Re: Existing Tank Application: # BRES2206-0060

An attempt was made to evaluate your property for the purpose of issuing an existing tank permit. The evaluation could not be completed for one or more of the following reasons.

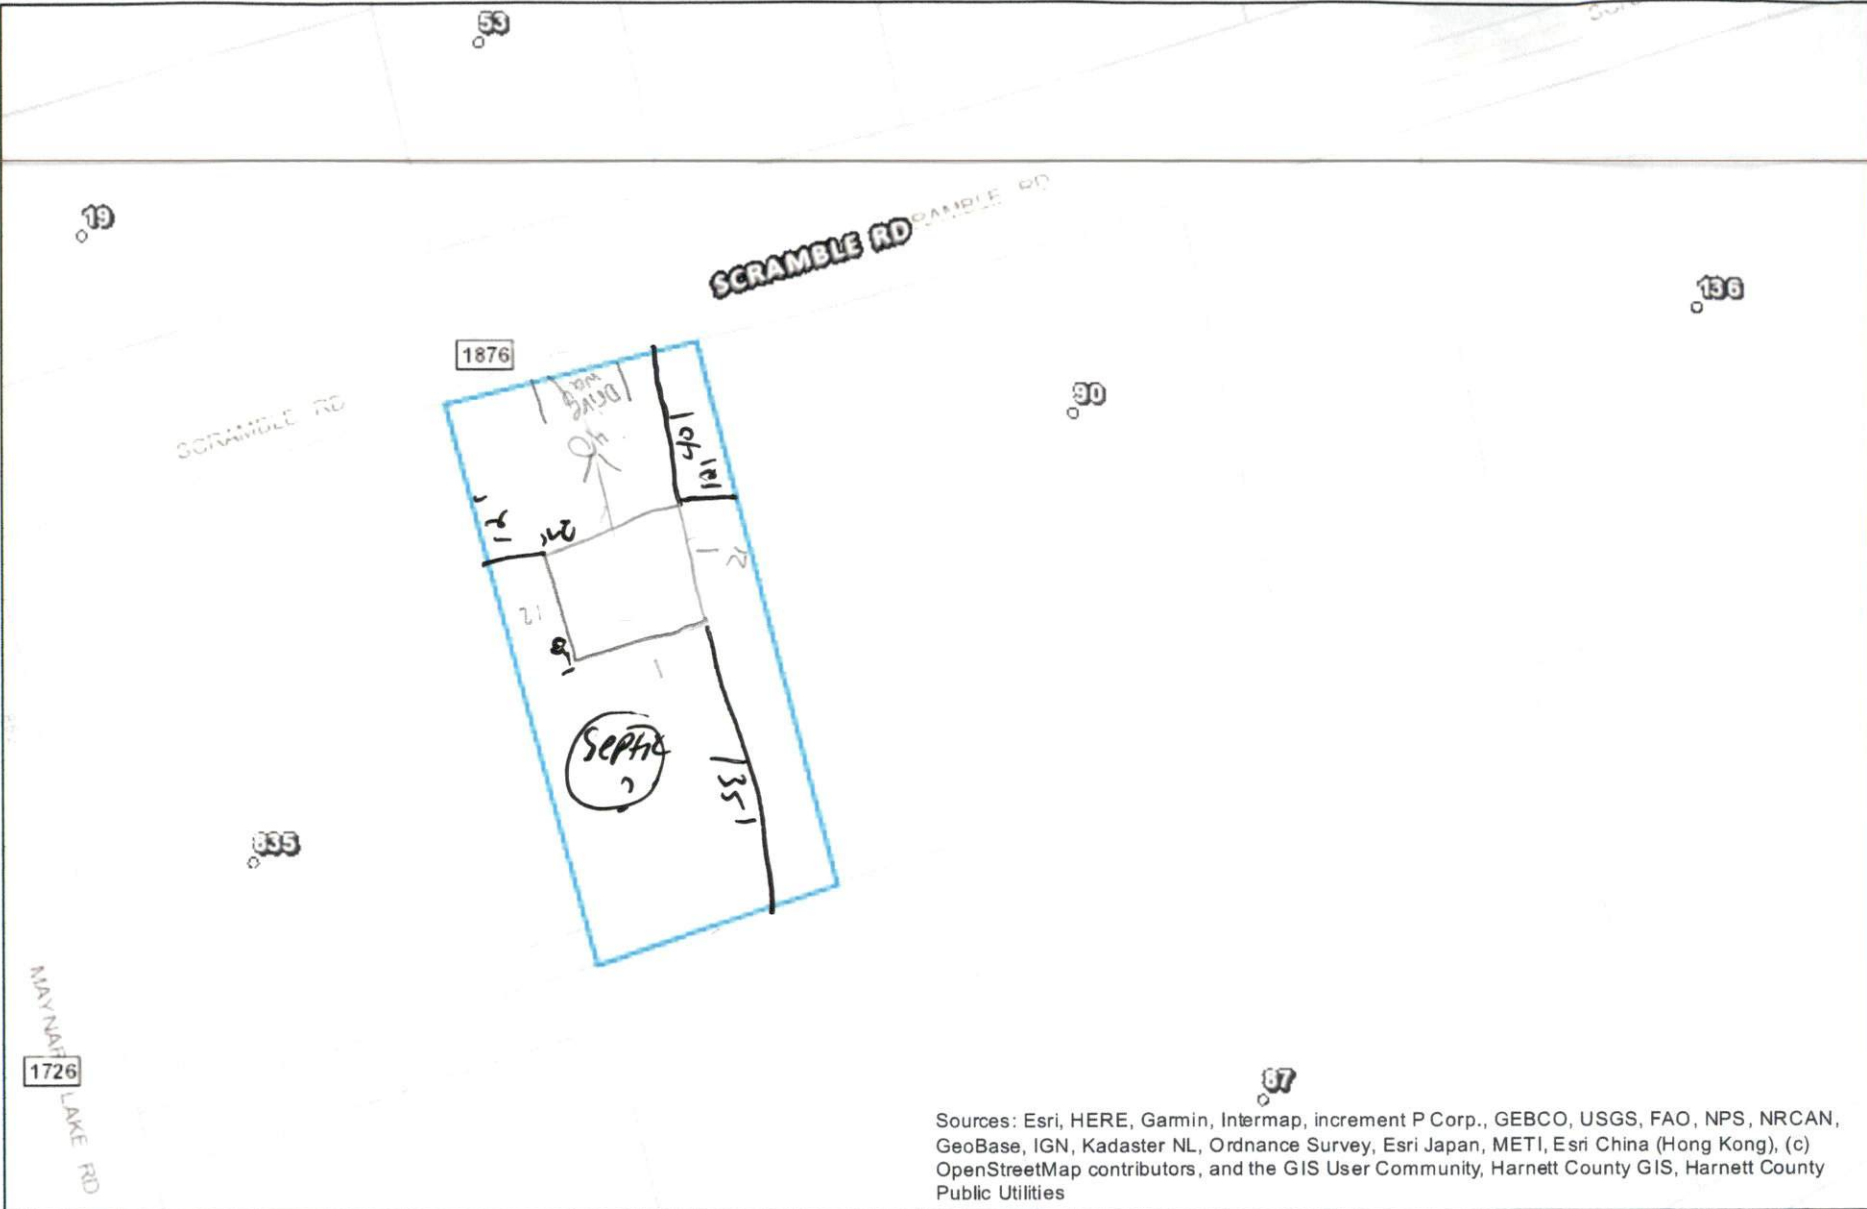
X 4. Other – Multiple Issues – House box not marked onsite. Site plan and setbacks appear questionable. Remark house and revise accordingly if varied for site plan. No property lines marked. Mark property lines with provided flags or stakes. Existing well proximity is unapproved. Site is home to a former Mobile Home greater than 20 years ago. Existing uncovered septic tank and drain field shall be located, identified, and inspected prior to any permit approvals. Coordinate with a licensed septic contractor or septic pumper to inspect existing system for structural integrity and function. Lot has overgrowth with dense vegetation for 20 years and system has been out of service. Advised to have licensed septic inspector coordinate with county inspector or provide septic inspection report.
